Response to Applicant's video of drive-through of proposed route for construction traffic

Figure 2-5 Indicative Construction Access and Compounds (Rev P01)

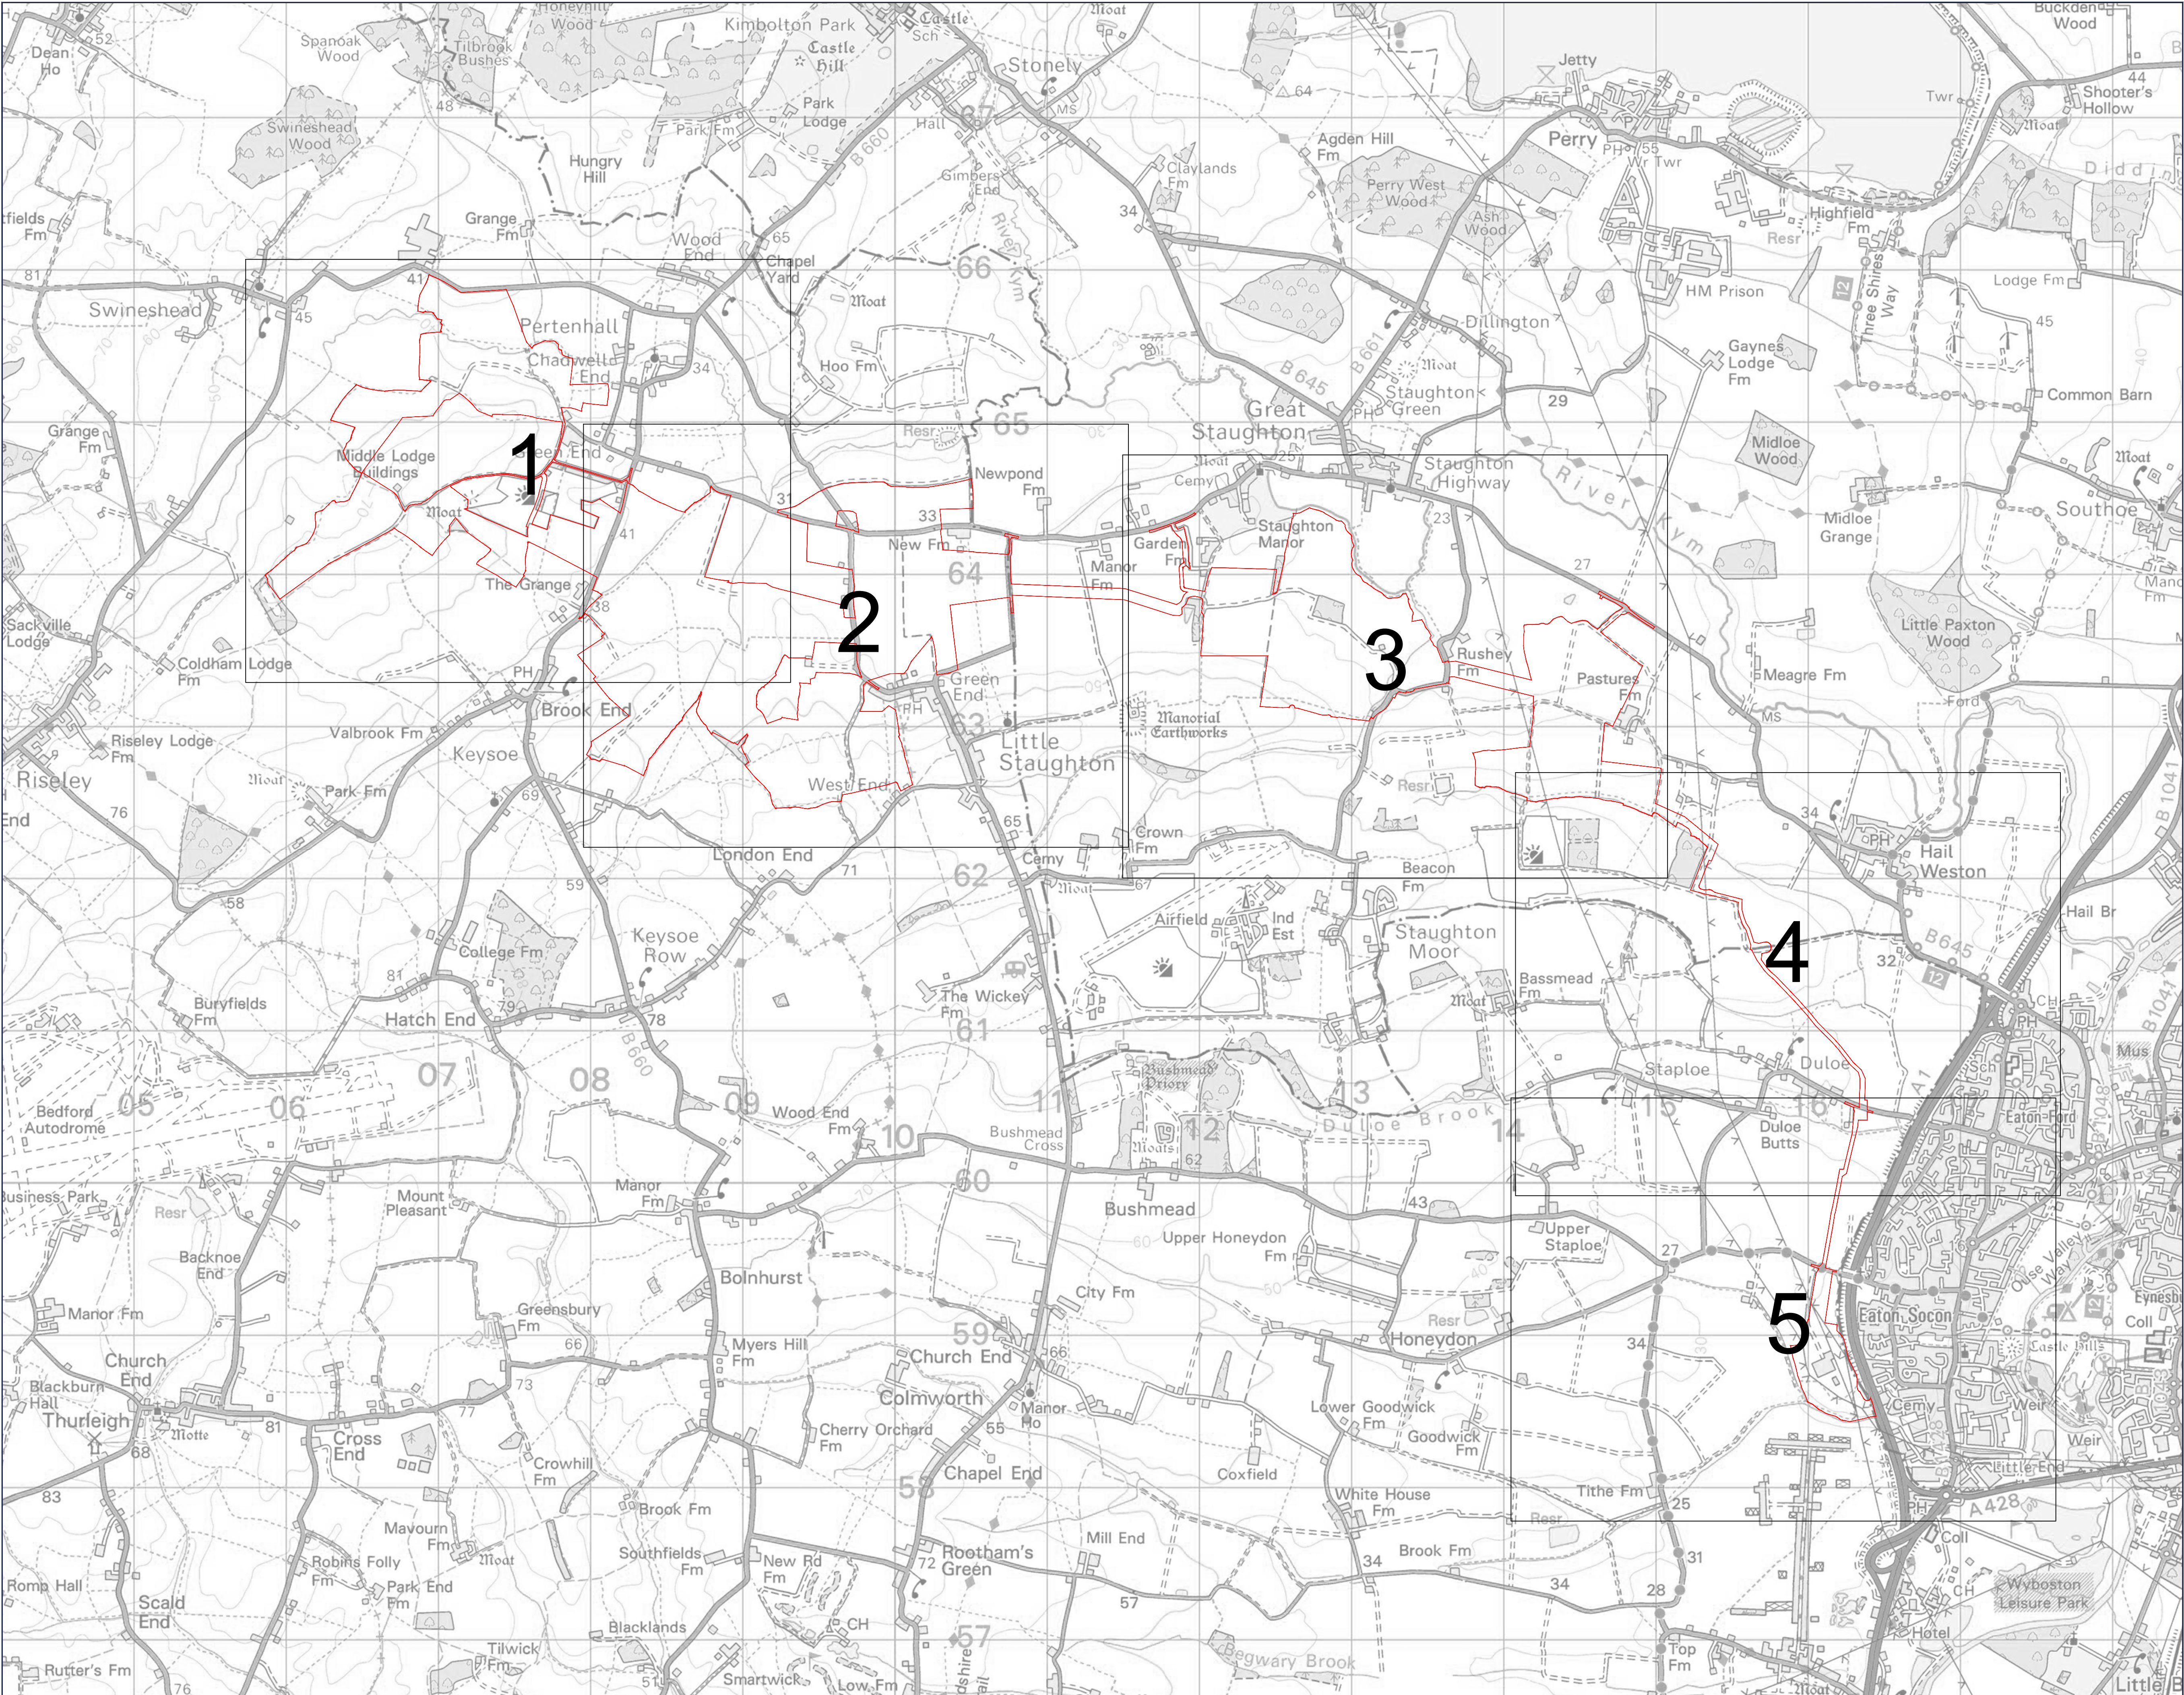
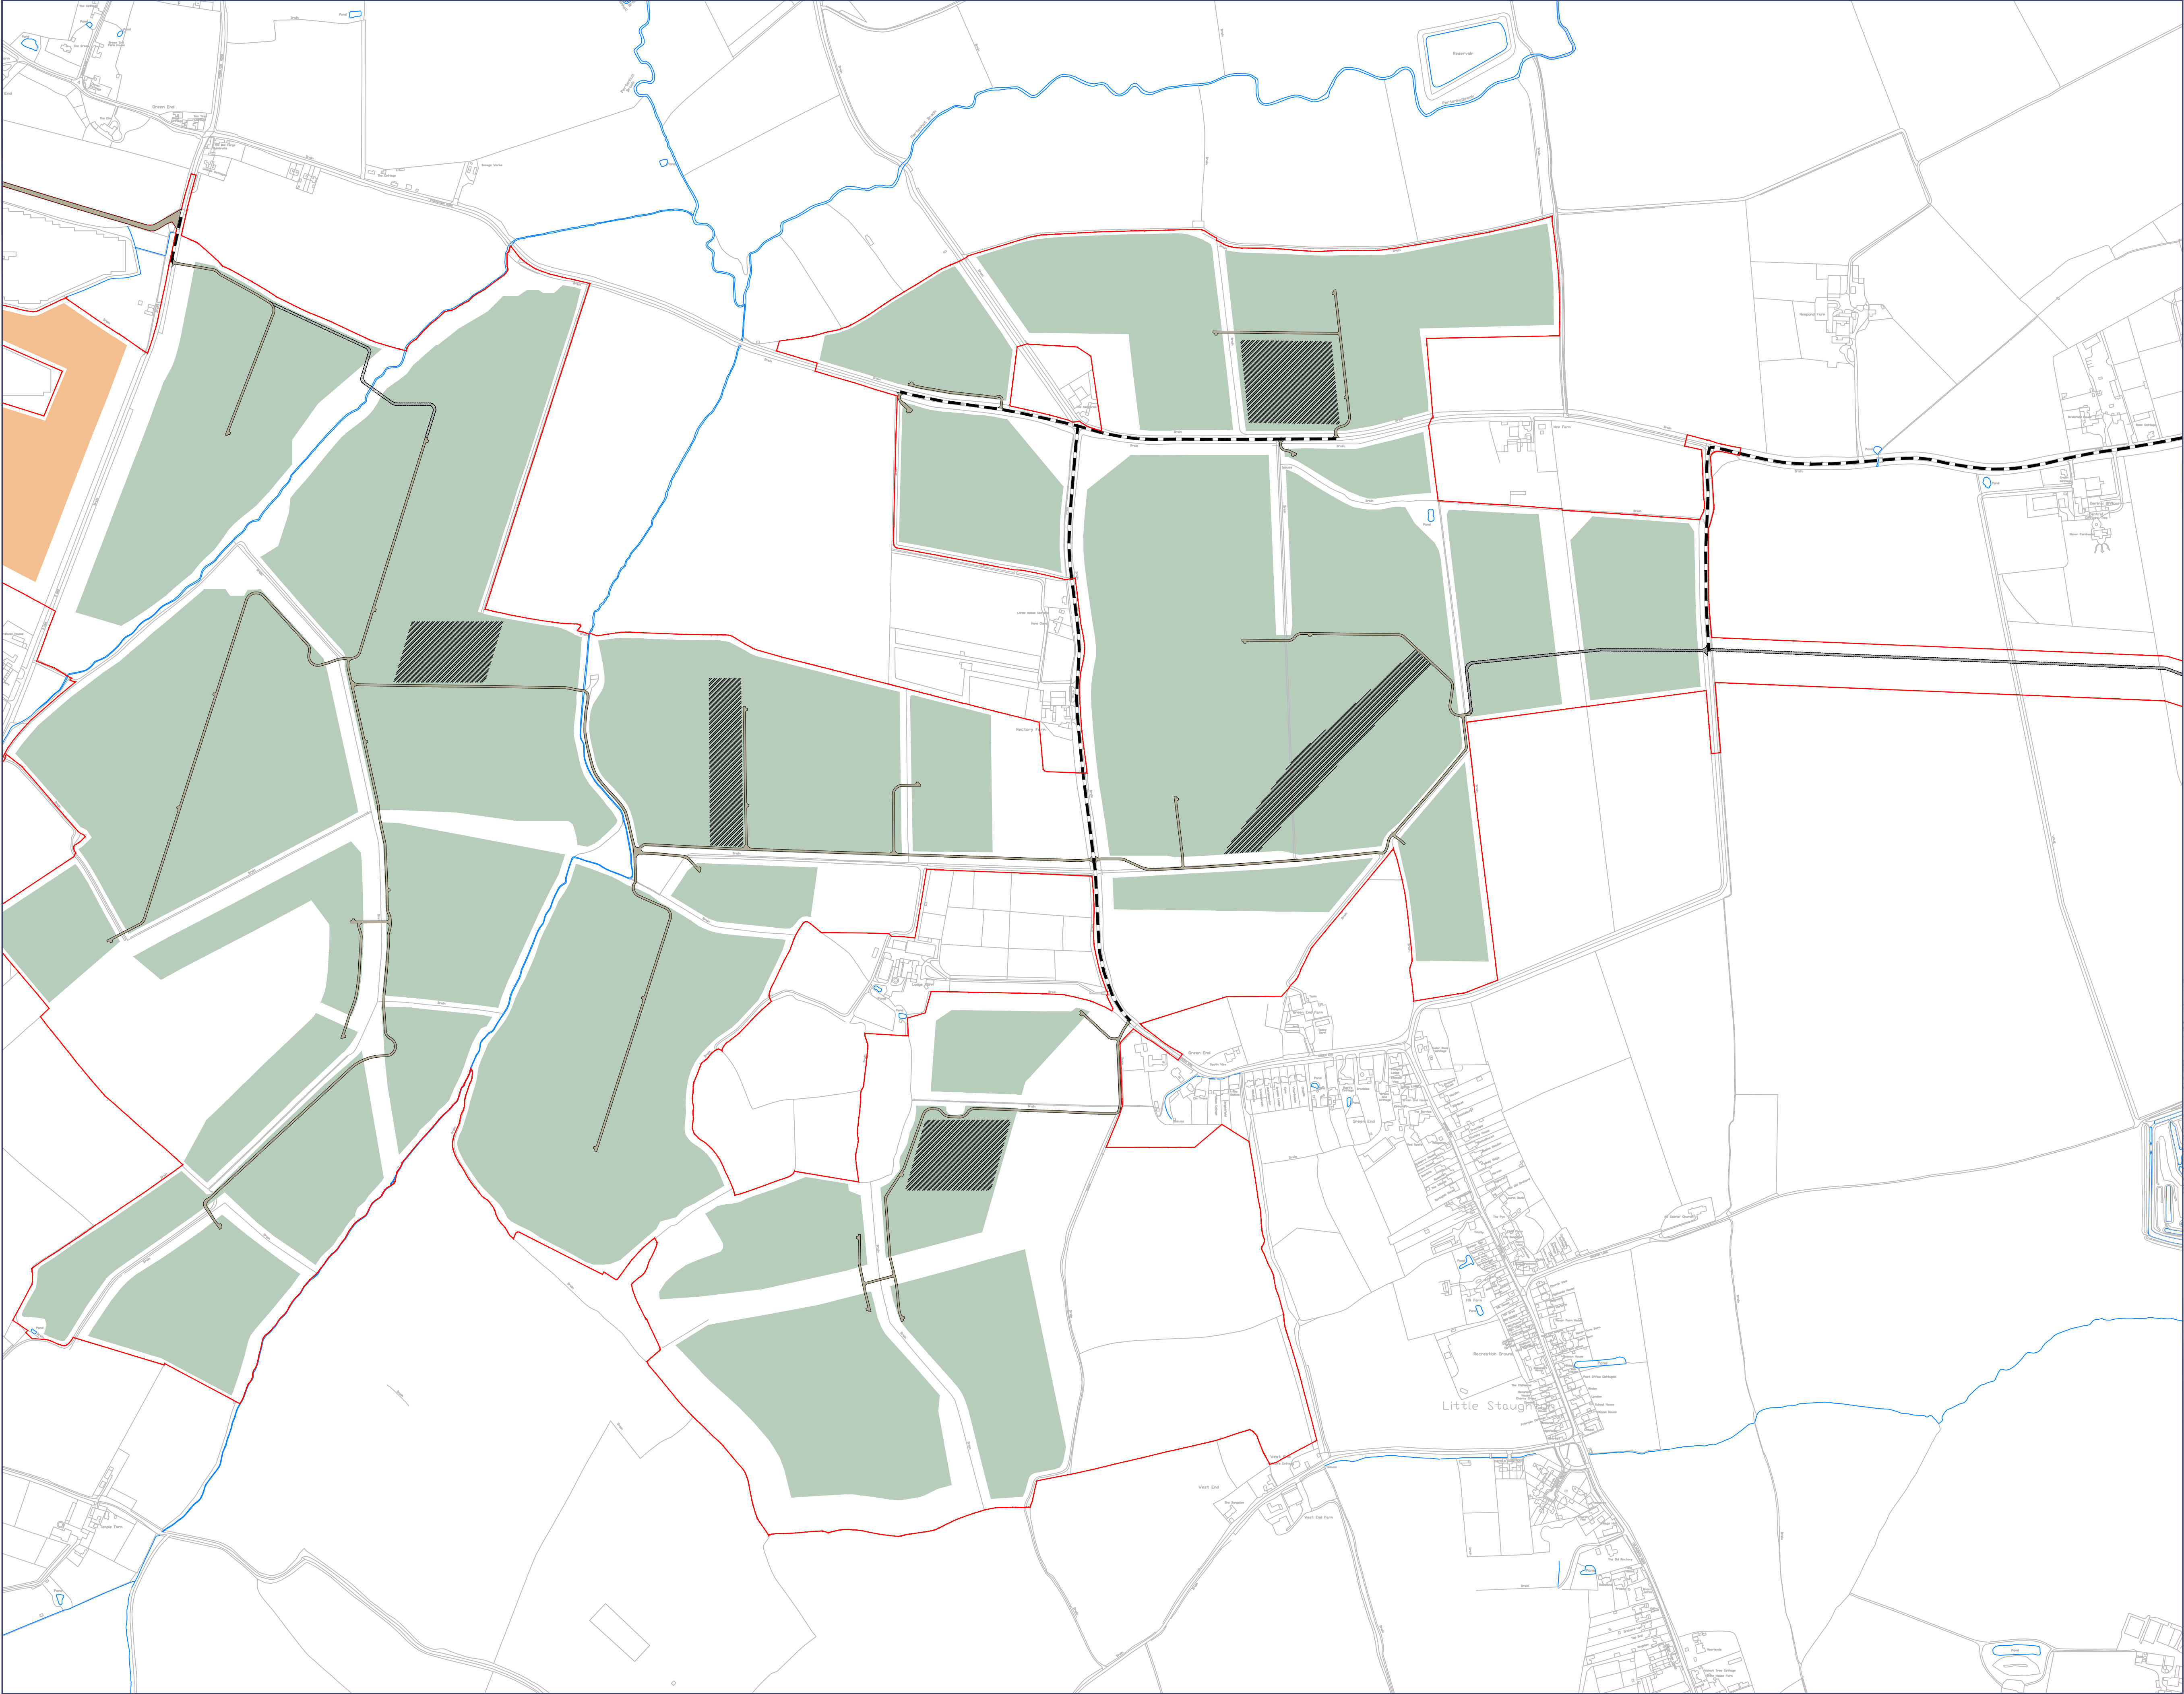
- Making the video from a HGV would have given a far more realistic view of the impact of the bends, hills and junctions that will be encountered by such vehicles during construction that may not be evident from a car.

- An indication of the time of day this video was filmed would allow a better estimation of the effects of peak traffic volumes at different times of day.

- The mileage and number of local highways being used is far greater than expected. This contradicts the Applicant's claim that constructing a temporary road network across the fields would eliminate disruption to local residents!

- Routes that will be used by HGVs during the operational stage when the temporary internal road is no longer available should also be shown as this impact will not be "insignificant".

- As HGVs and workers are only being "encouraged" to use these routes, driving routes to the different areas using only GPS guidance would show the potential impact of likely alternatives/short cuts. This would give a much more realistic portrayal of the unsuitability of the local road network which will be impacted by this scheme.
